<b>Consultation Response from KC Landscape</b>	
<b>Application No:</b>	2023/92712
<b>Proposed Development:</b>	Erection of 40 bed care home and 12 independent supported living units (use class C2) with associated works including the formation of car park and service access
<b>Location:</b>	Land adjacent, 36 Oxford Road, Dewsbury, WF13 4LL
<b>Applicant/Agent:</b>	Farrell & Clark LLP
<b>Planning Officer</b>	Nick Hirst
<b>Date Responded:</b>	06.11.23
<b>Responding Officer:</b>	EM
<b>Responding Ref:</b>	MM97

Plans considered/reviewed: Soft Landscape proposals Drwg: 711.03 Date Sept 23  
 Setting – this layout for 40 bed care home plus 12 self contained single bedroom units  
 Planning statement refers to secure space rather than public open space on site.

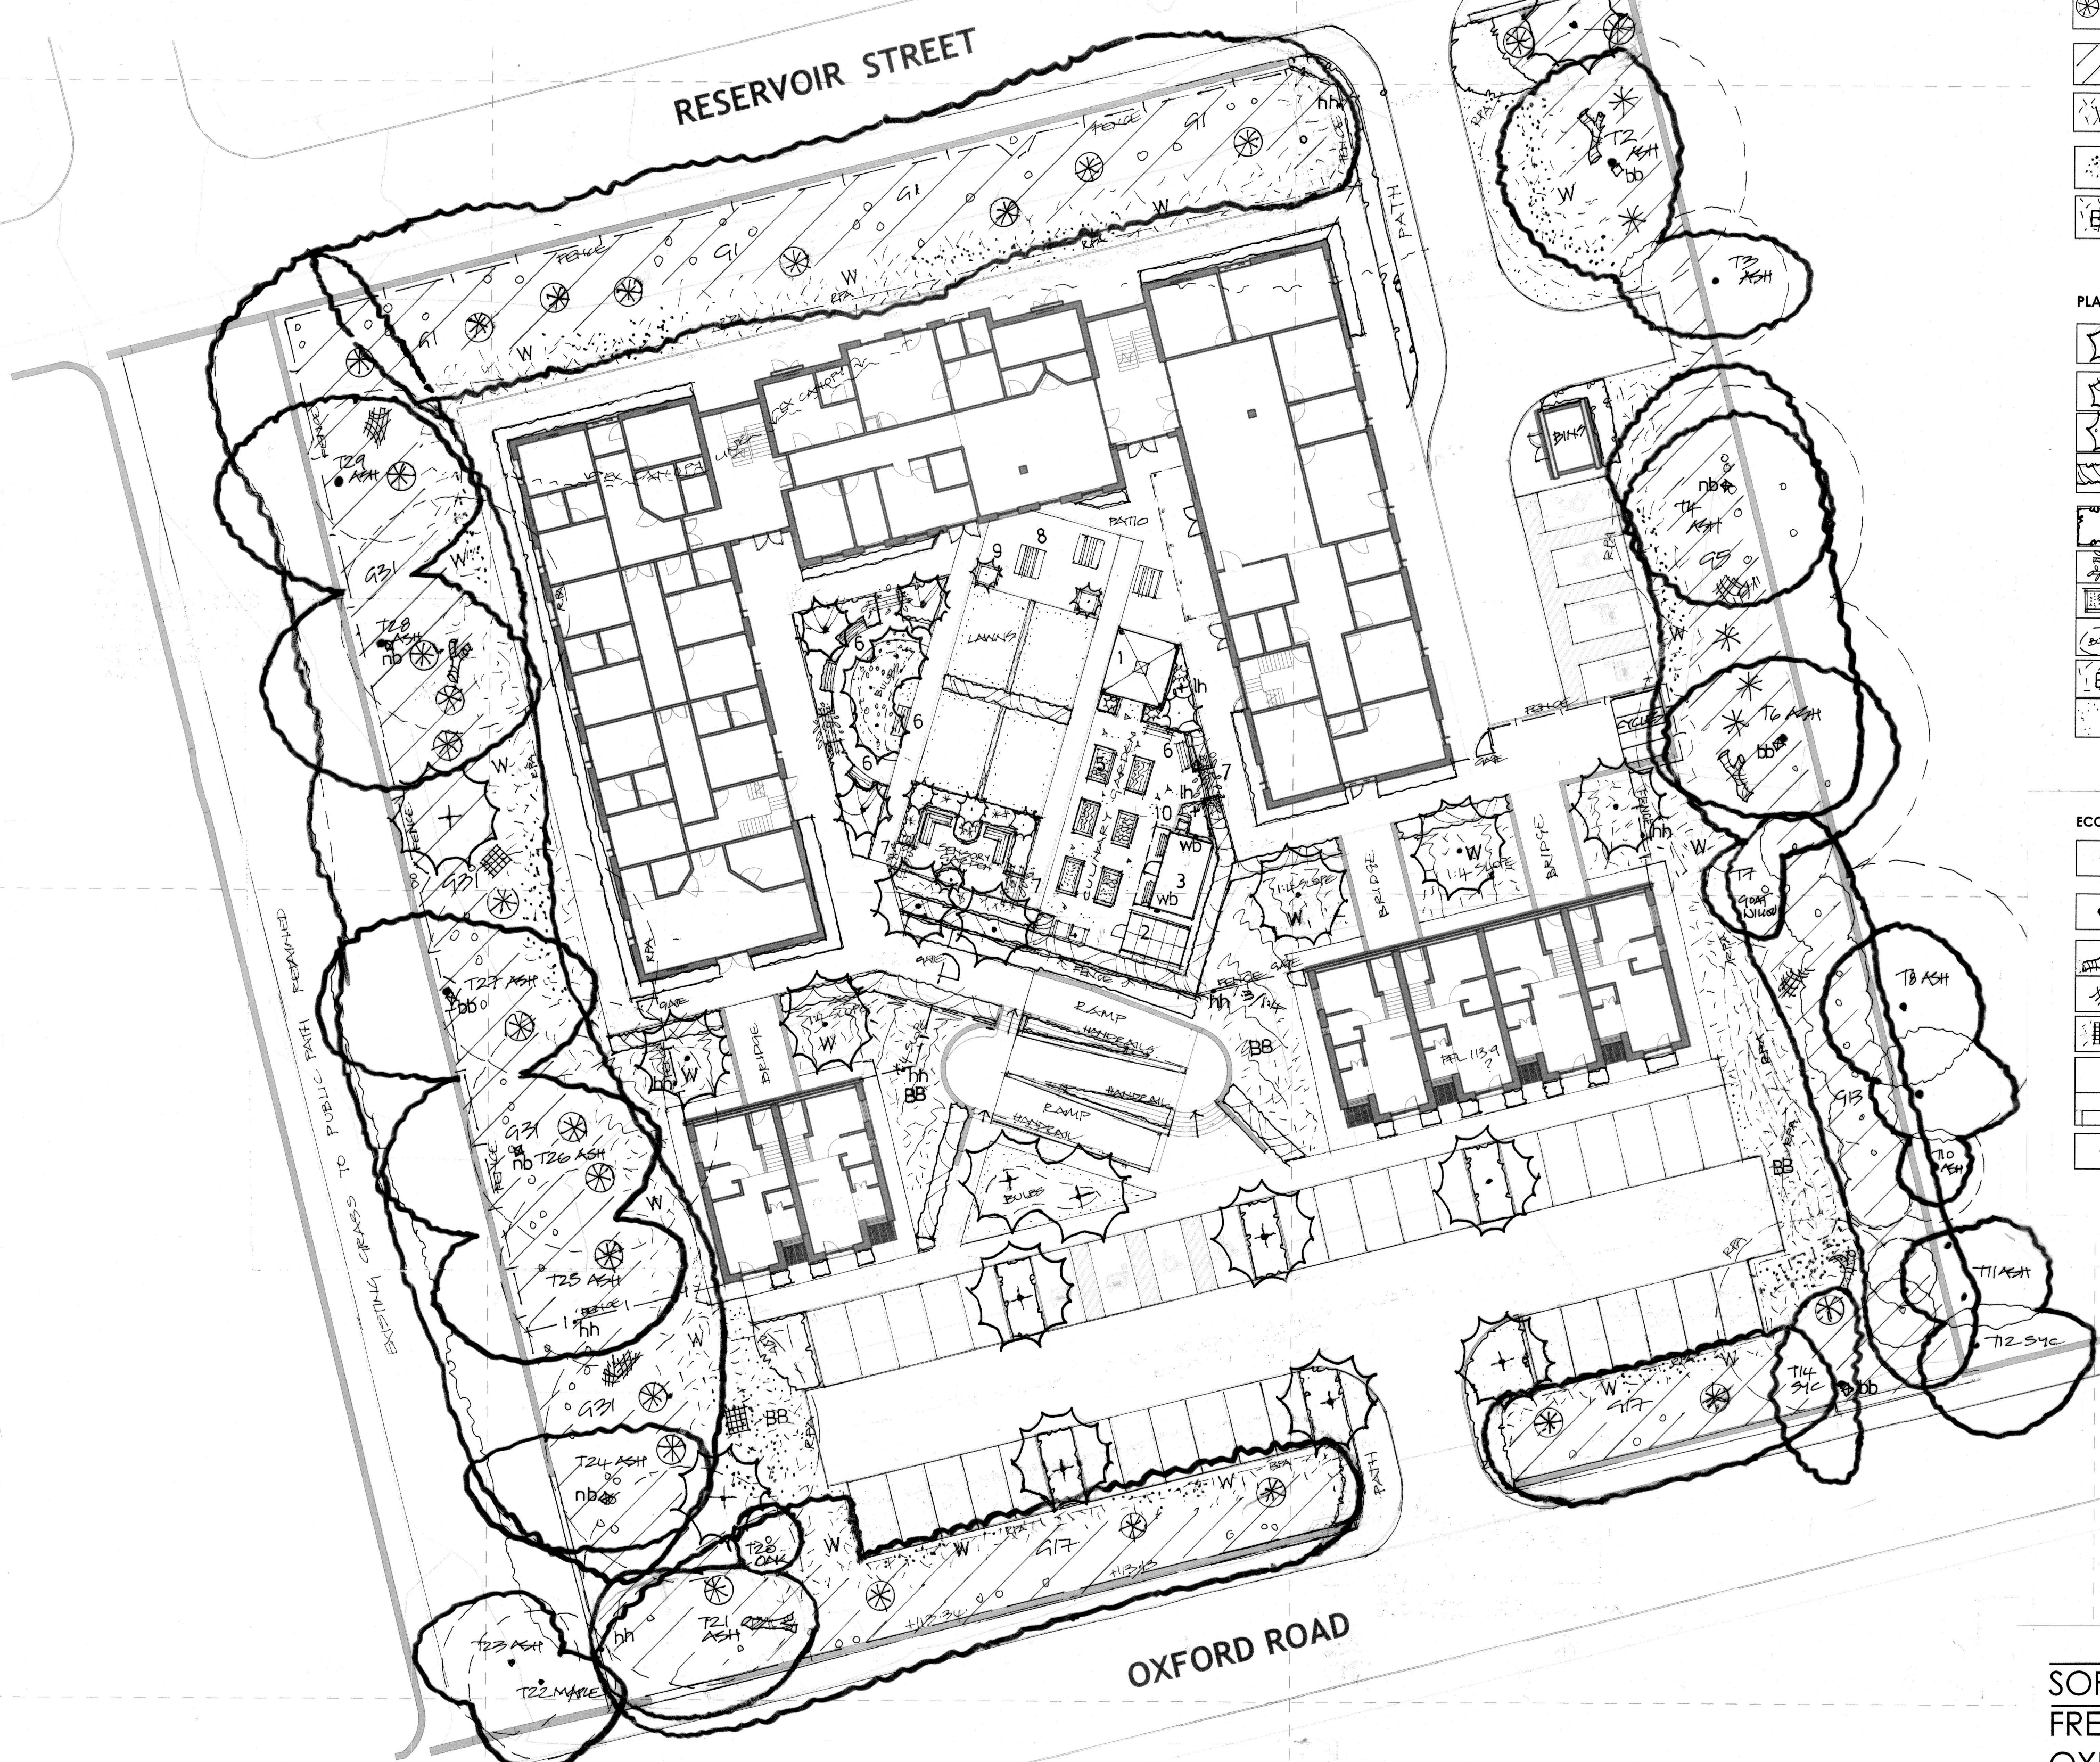
2. The proposed landscape layout drawing no. 711.03 is sympathetic to the proposed users of the site, creating safe spaces with a variety of landscaped spaces, sensory planting and different uses.

3. We welcome the use of tree planting in the car park to reduce dominance of hard surfaces/car parking bays

4. It doesn't look like any management plan for the scheme has been submitted. We will need to see a management plan for the landscaping scheme to ensure the scheme successfully establishes. The management of newly establishing trees should include, but is not limited to, a watering regime, monitoring of stakes and ties, formative pruning, replacement of failed or damaged trees.
